Recommendation Report for Planning Permission for Works or Extension to a Dwelling

REF NO: LU/267/21/HH

LOCATION: 21 East Ham Road
Littlehampton
BN17 7AW

PROPOSAL: Erection of single storey side extension, single storey other side porch extension and alterations to fenestration following the demolition of existing side extension

REV	NOTES	DATE
 INTERIOR ARCHITECTURE + DESIGN		
PROJECT 21 EAST HAM ROAD Littlehampton, West Sussex, BN17 7AW		
DRAWING Existing & Proposed Plans		
DRAWN BY JP	SCALE 1:50 @ A1	REVISION
DATE Aug 2021		
DRAWING NO. 10043 - DPA - 002

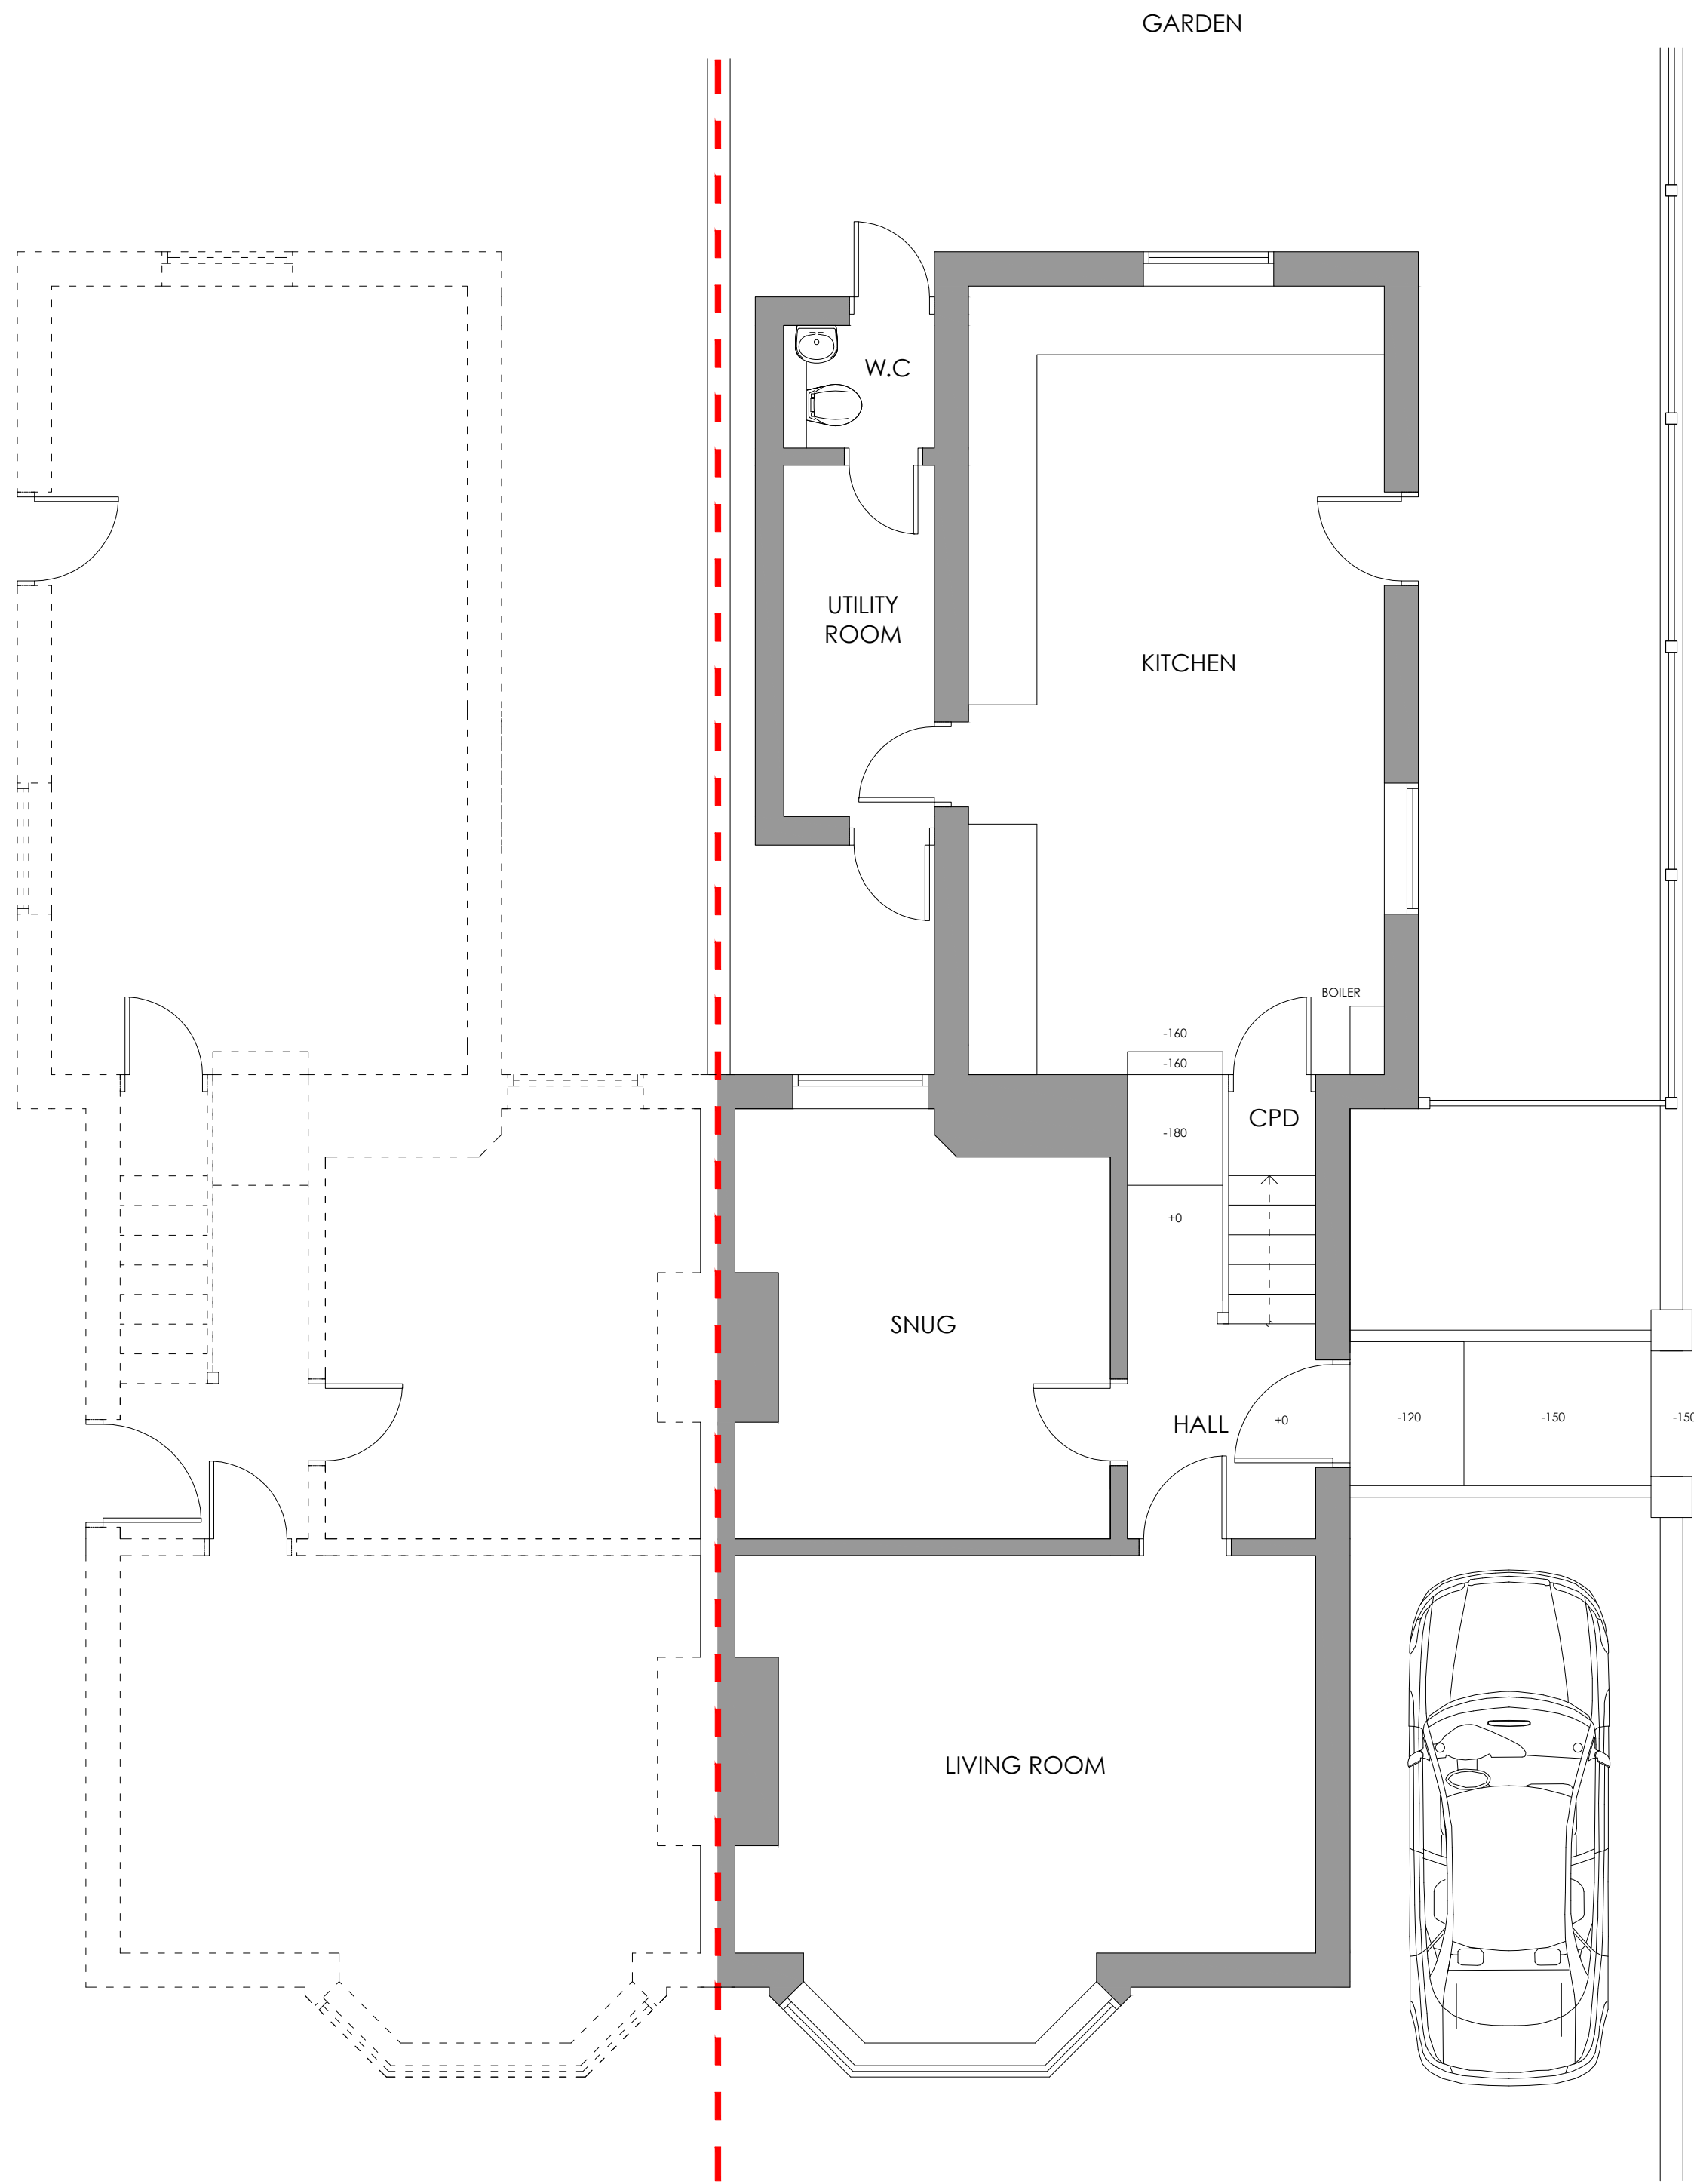
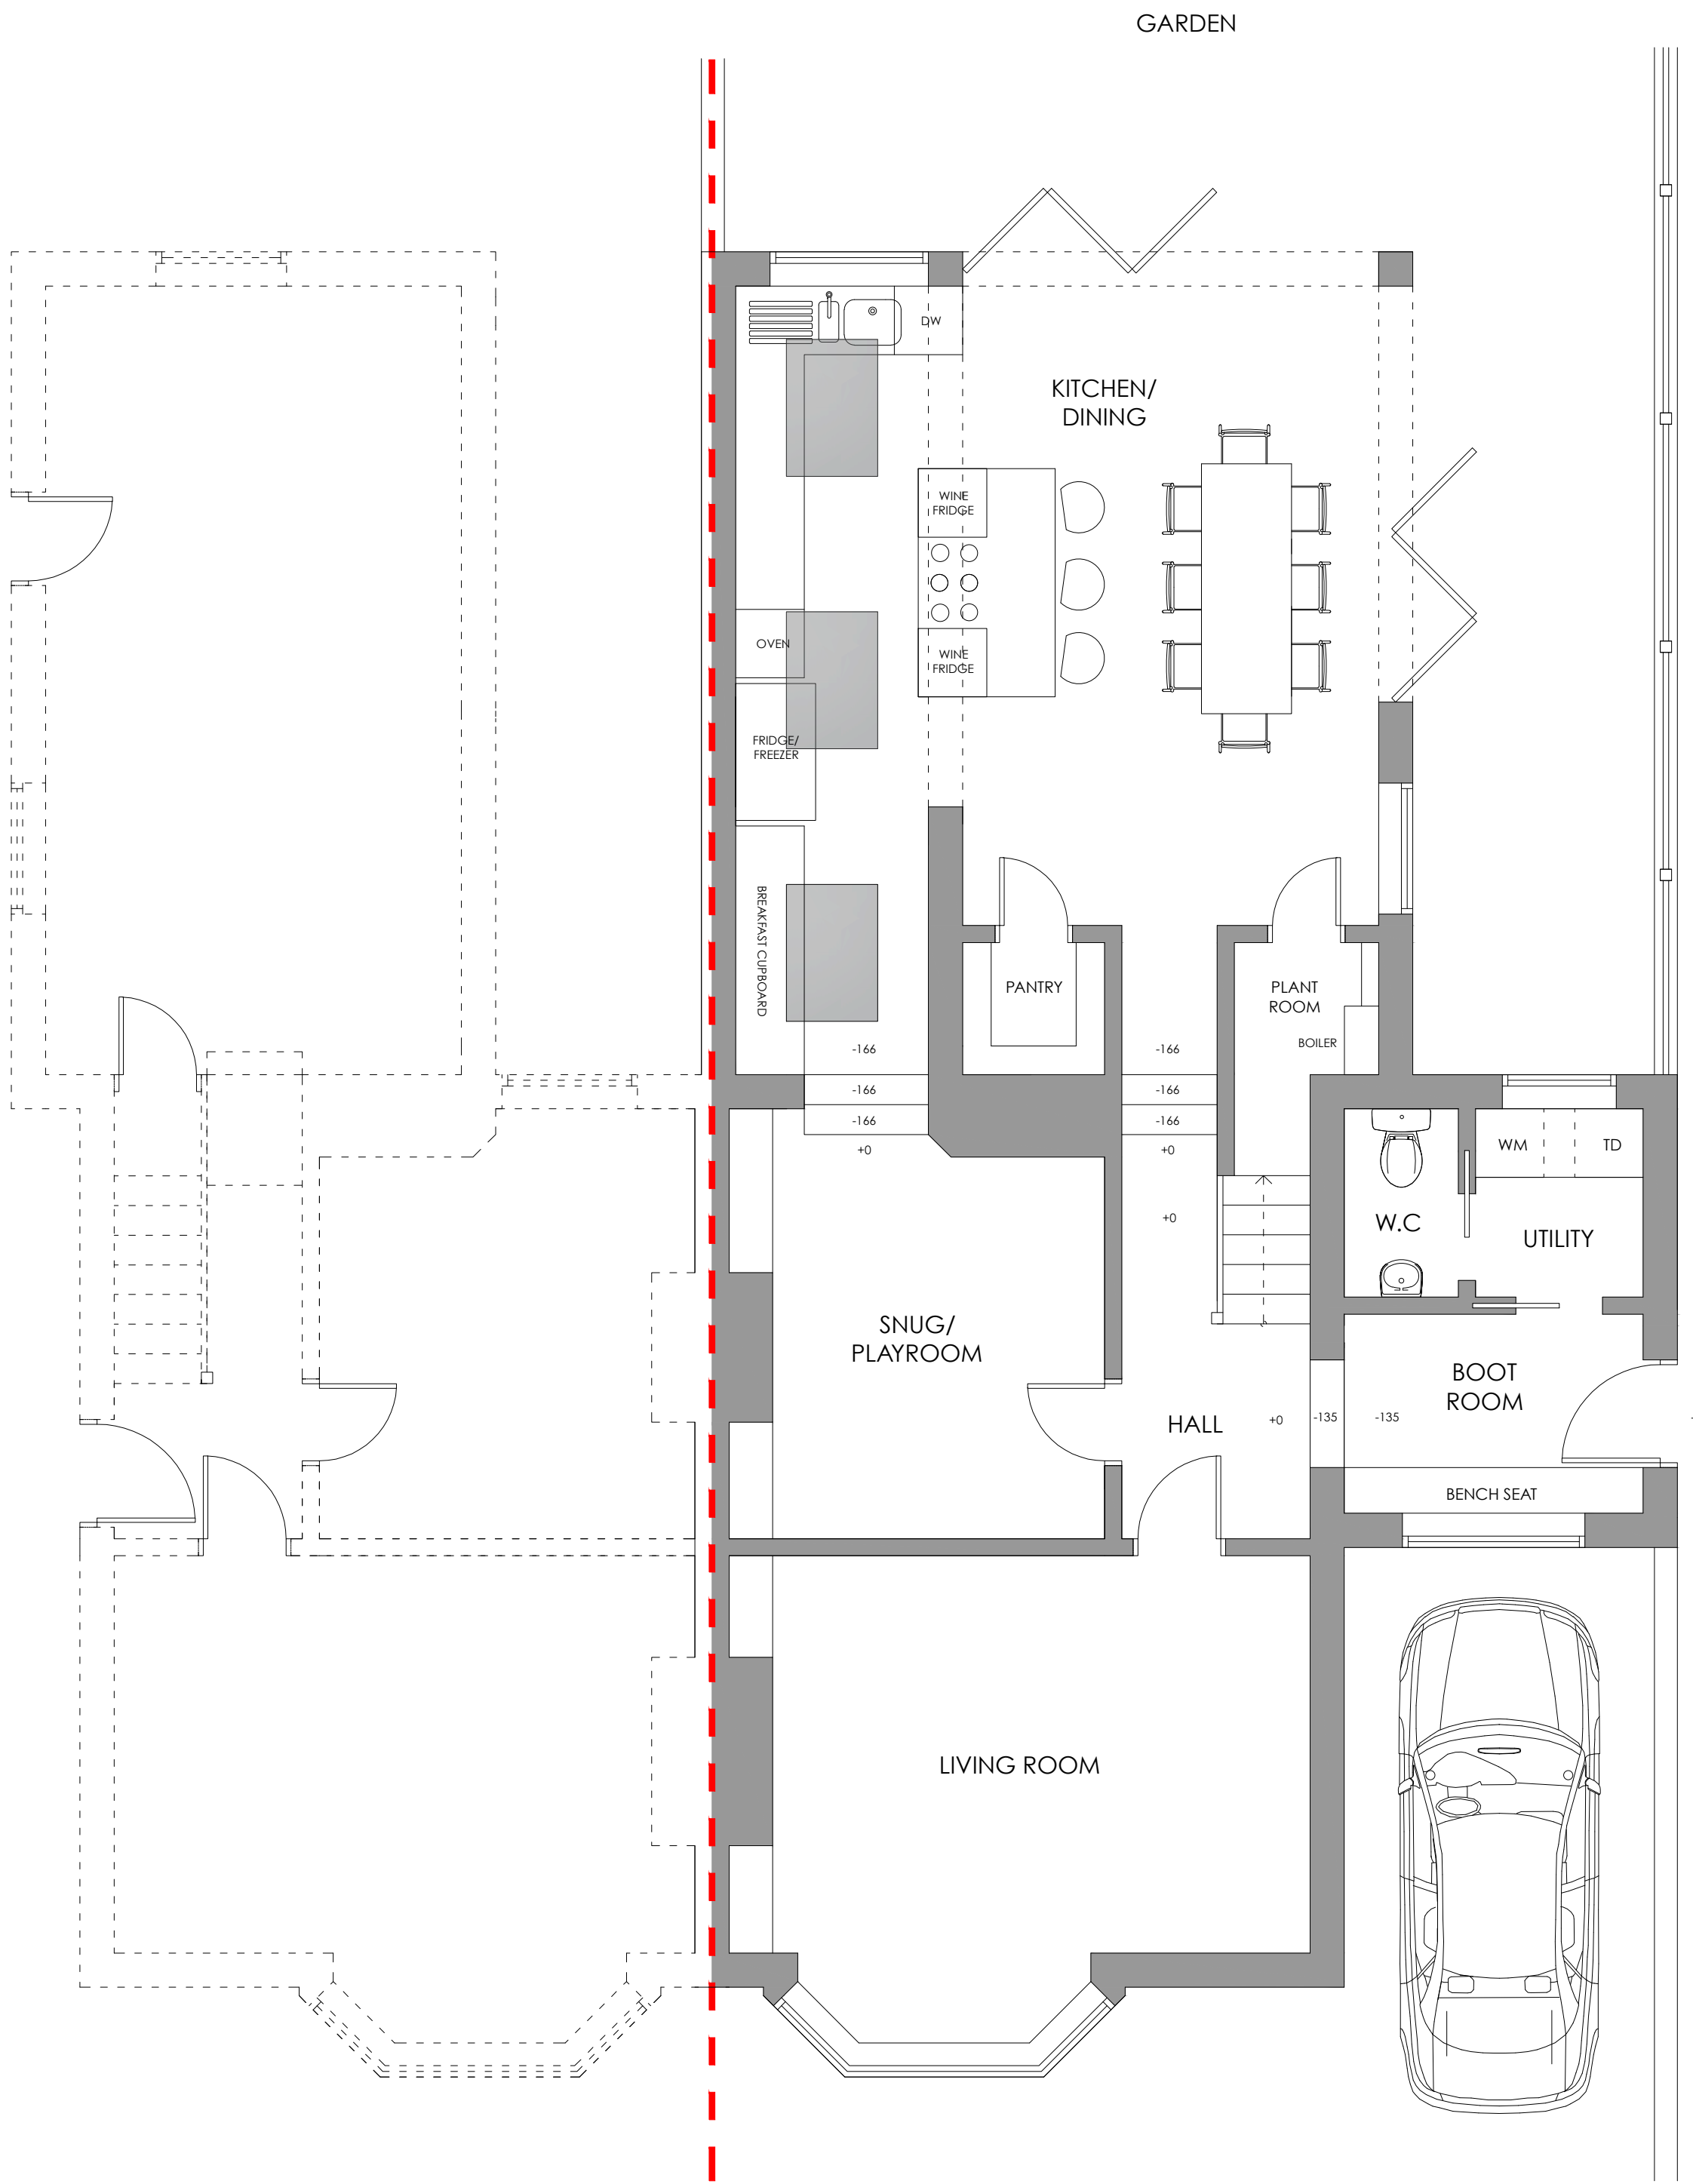
DESCRIPTION OF APPLICATION	Single storey side extension measuring approximately 2.8m in width by 4.2m in length and the demolition of existing rear lean-to extension and erection of a replacement flat roof extension measuring approximately 1.5m in width by 4.7m in length.
----------------------------	---

The single storey side/front extension is not located adjacent to other properties being set between the host dwellings frontage and the street, it is also only afforded views of the public realm. It is therefore considered not to overbear, overshadow or overlook neighbouring properties.
